CITY OF PORTLAND

BUILDING PERMIT

Job ID: 2012-06-4269-ALTR

has permission to Add farmers porch

FRONT ELEVATION PLAN
COVERED PORCH

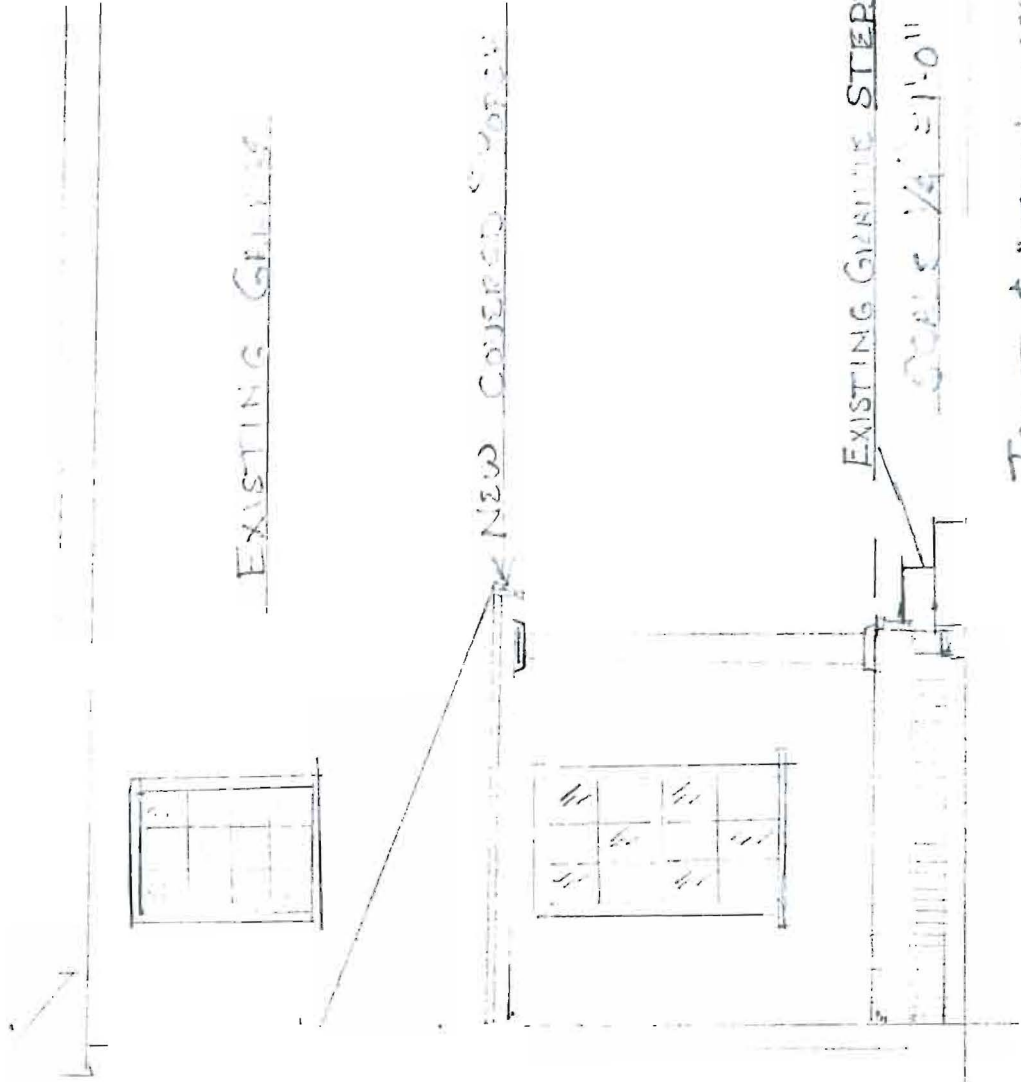
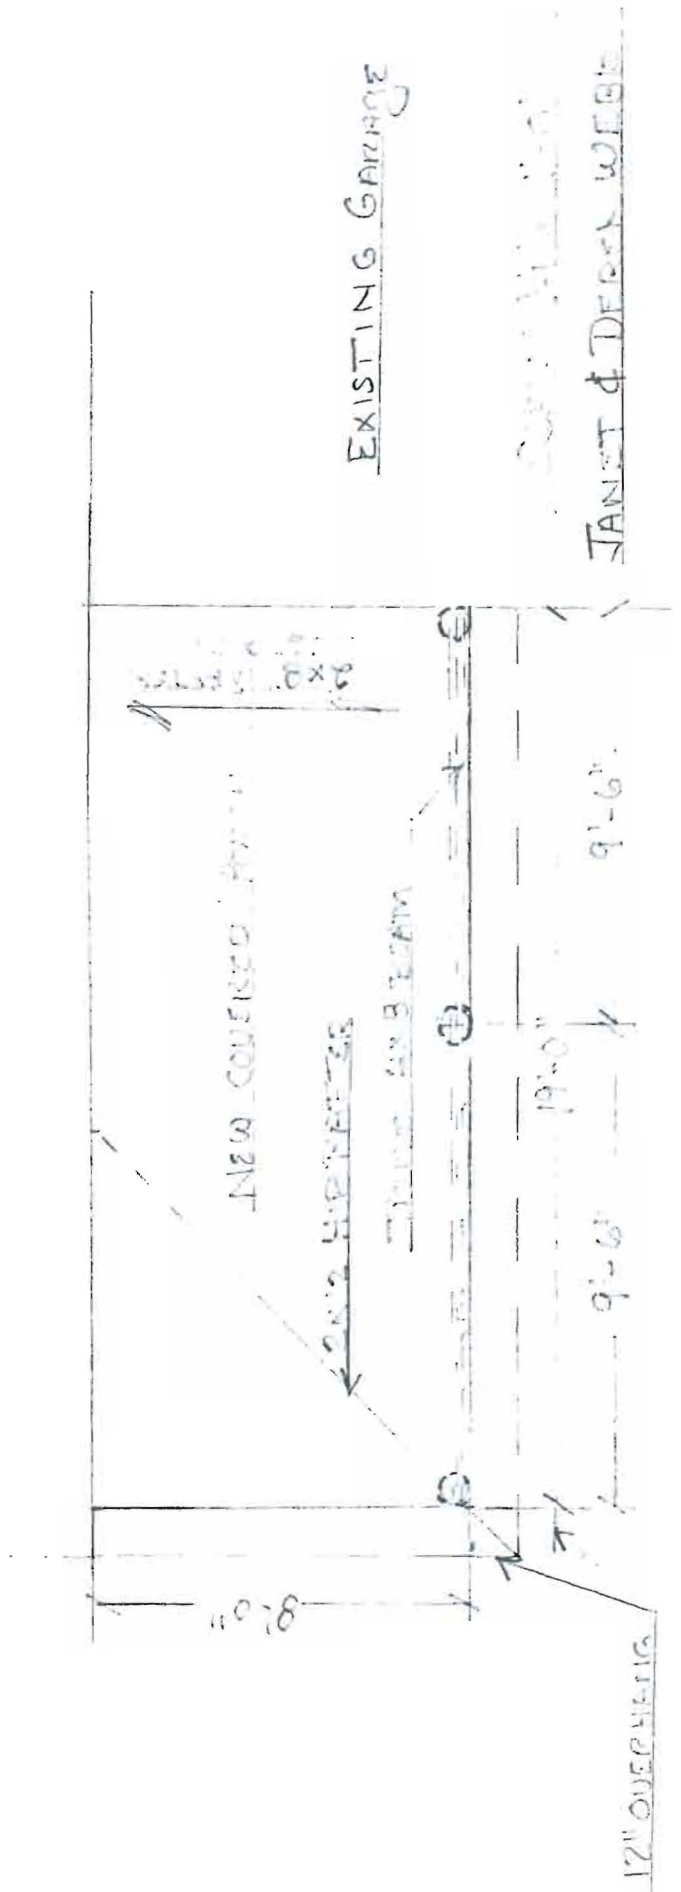
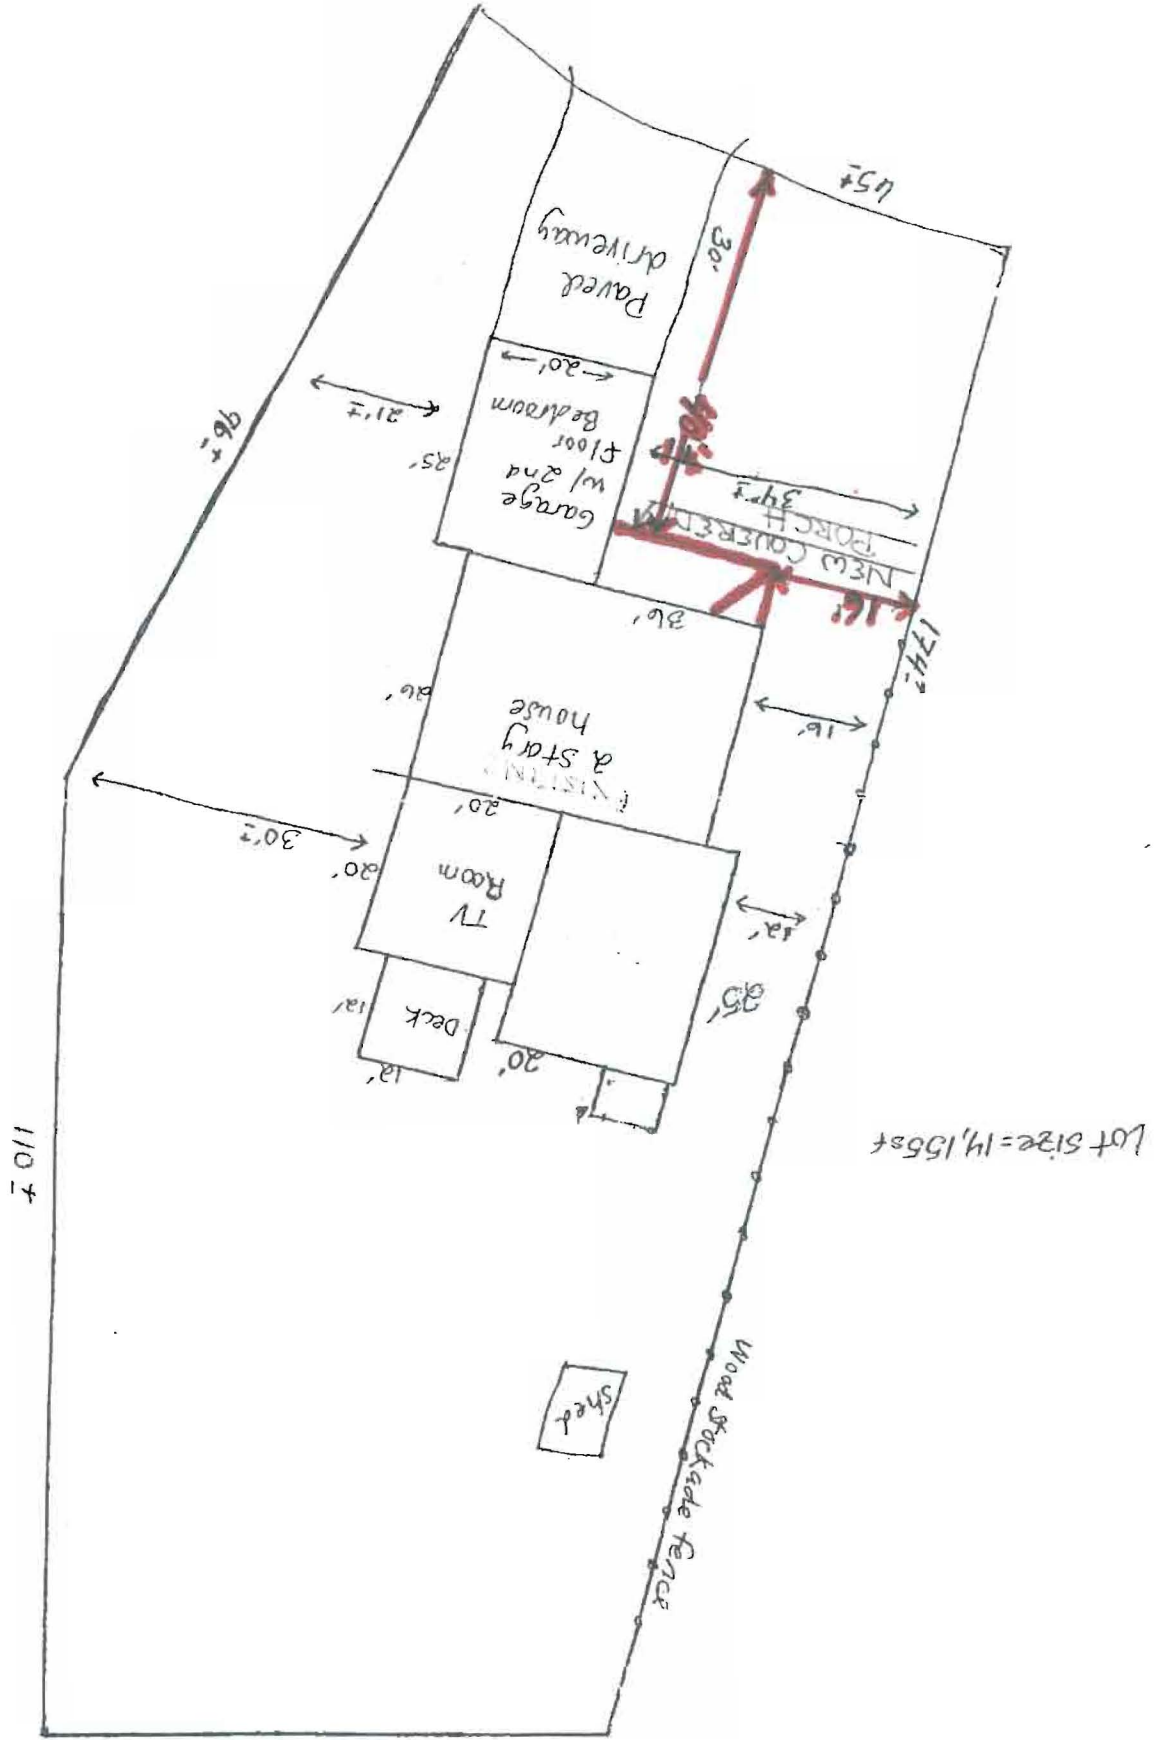
1. Separate permits are required for any electrical, plumbing, sprinkler, fire alarm HVAC systems, heating appliances, commercial hood exhaust systems and fuel tanks. Separate plans may need to be submitted for approval as a part of this process.
2. The carrying beam for the roof carrying the rafters must be 3- 2" x 10"-s.
